Your Ref: 000013361
Our Ref: EP/70/12/ 27-06-2012
Please ask for:
Mr P Cleveland

Alterations & first floor extension, providing a reduced garden room on the ground floor, together with conversion of garage to a gym & 2 new bedrooms, study & bathroom to first floor. Removal of existing pitched roof & replace with lower mono pitched roof
Sandgate House South Strand East Preston Littlehampton

Thank you for your internet representation made on 8th August 2012 which has been recorded as **an objection** with the comments as follows:

1207 SK26
 Sandgate House, East Preston
 Elevations As Proposed - sheet 2
 June 2012
 scale: 1:100

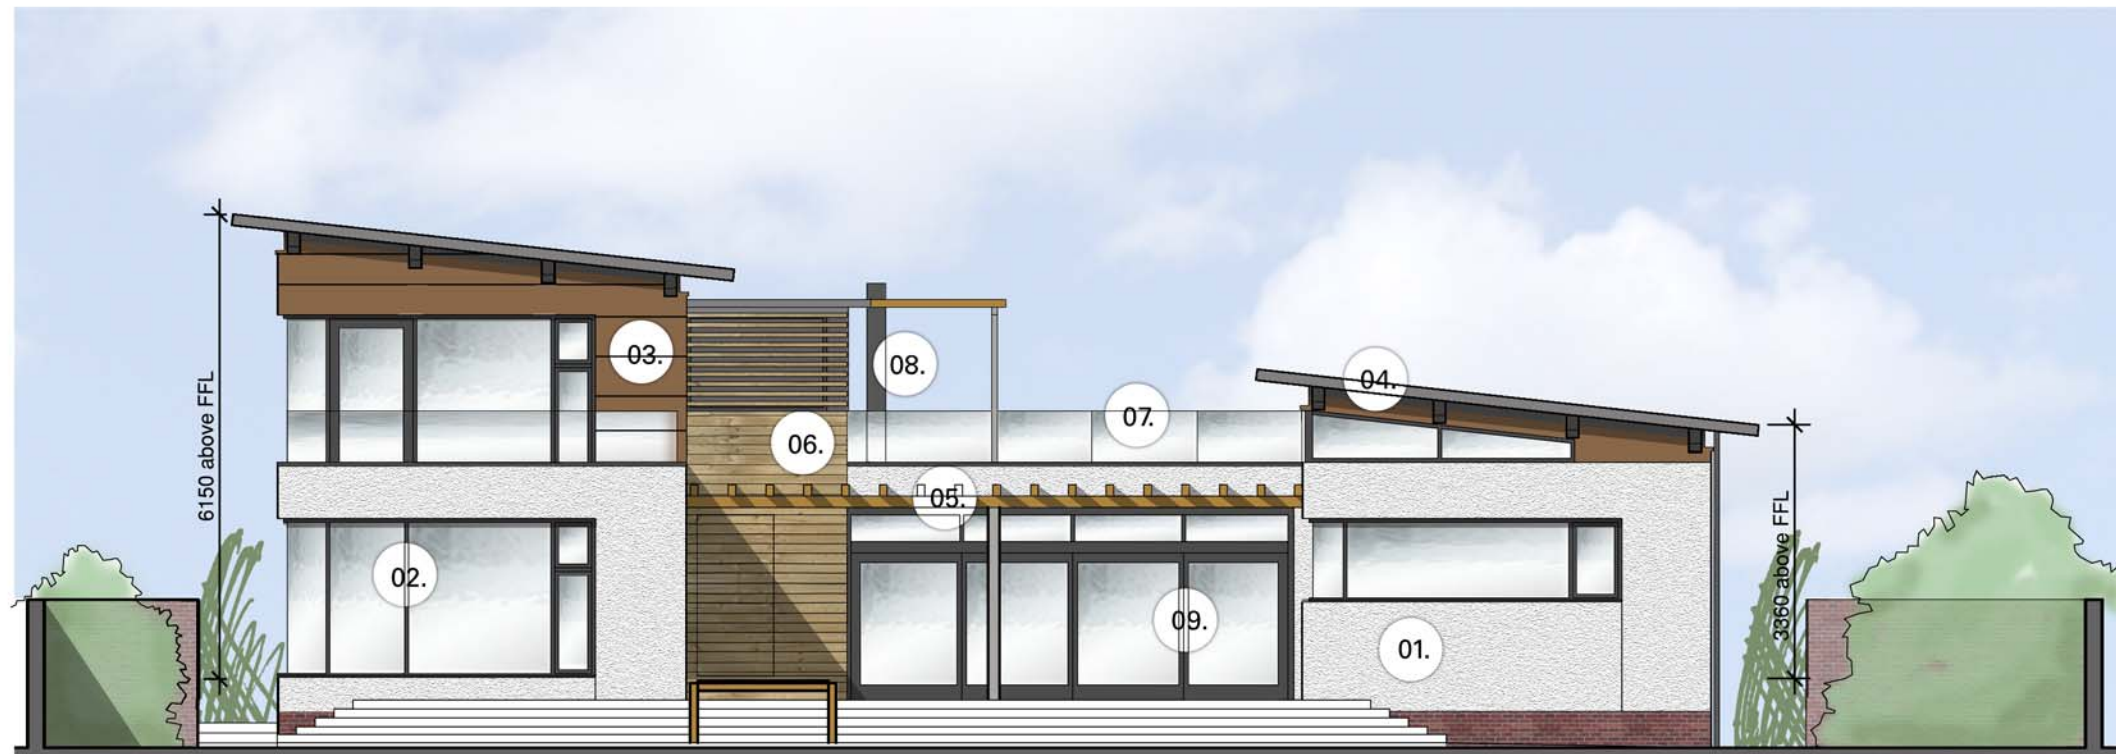
I object to the planning application EP/70/12 on the basis that this section of the beach preserves the rural/wild unusual appeal of this area. □
This application would be overbearing particularly to the properties to the east and north. A raised first floor would eradicate views to the beach from the original historic properties on South Strand. □
At the time of this original property being built, there was a covenant protecting any development in height. Surely this should be preserved?
